26 November 2024

Proposed demolition of existing garage and erection of 2 storey side and rear extension at 31 Stafford Hill Lane, Kirkheaton, Huddersfield, HD5 0EE.

Application reference 2024/92912

Proposed Side Elevation

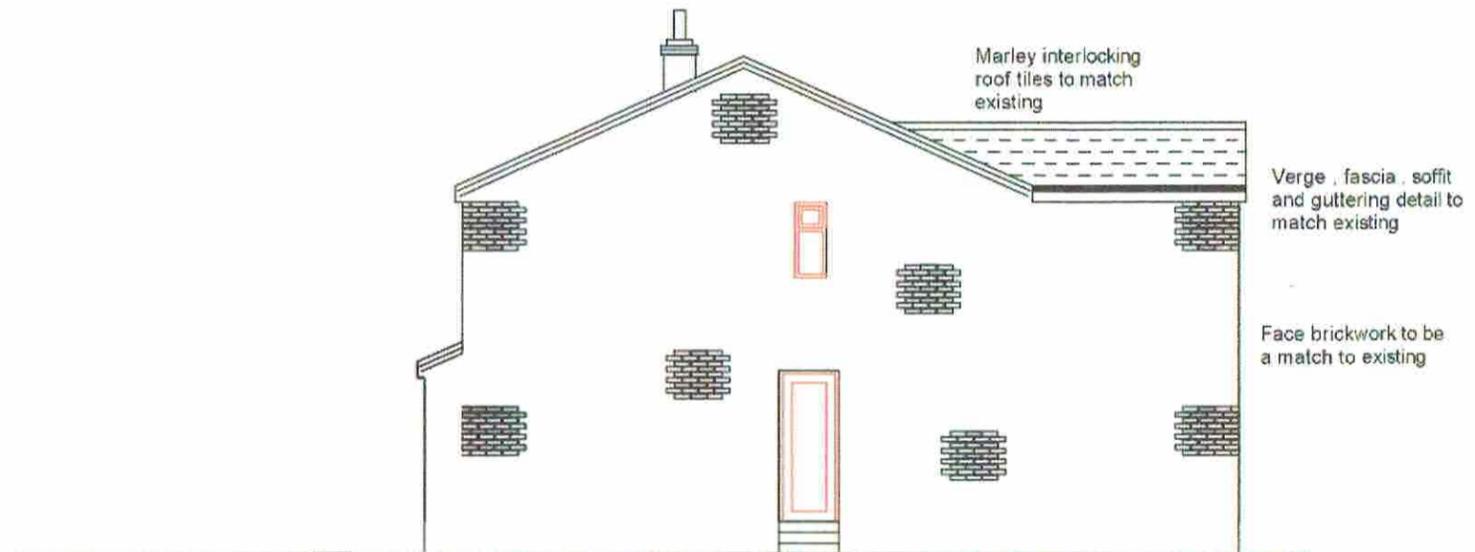
Given the orientation of the two properties, the proposals will block out late afternoon and evening sunlight resulting in an even greater adverse effect on the level of amenity

Proposed Front Elevation

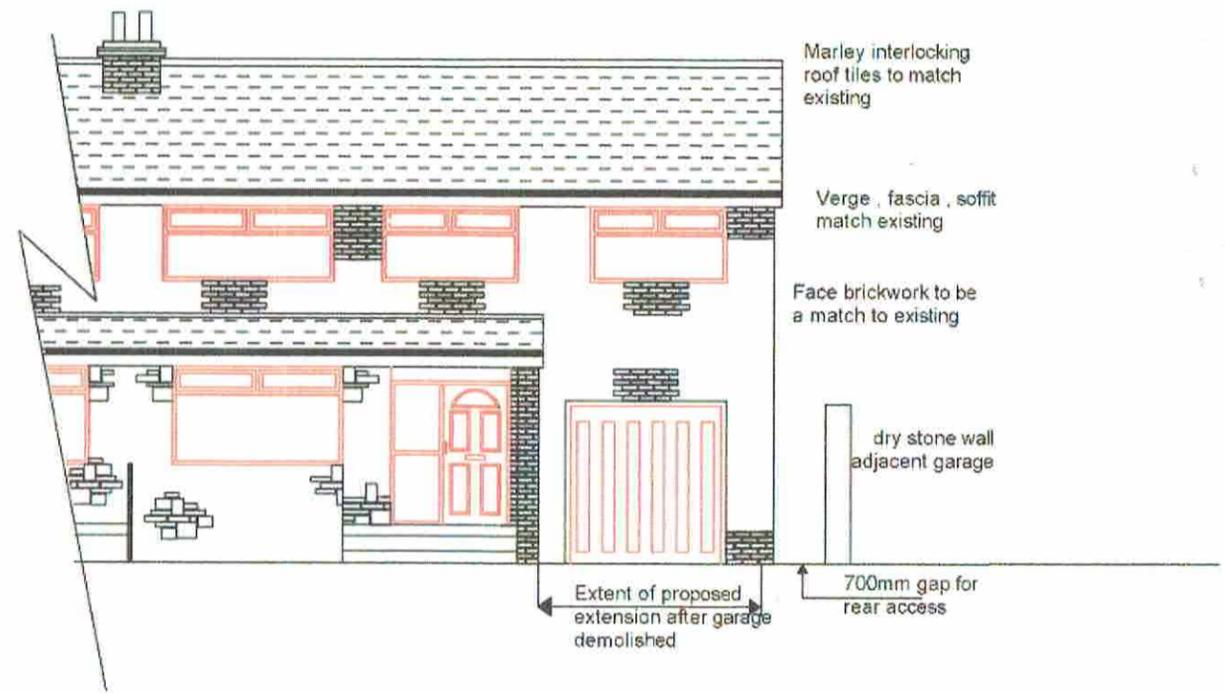
The application property occupies the right- hand of a pair of semi- detached properties as seen from Stafford Hill Lane. Neither property has been extended. The proposals will upset the symmetry of the pair of properties.
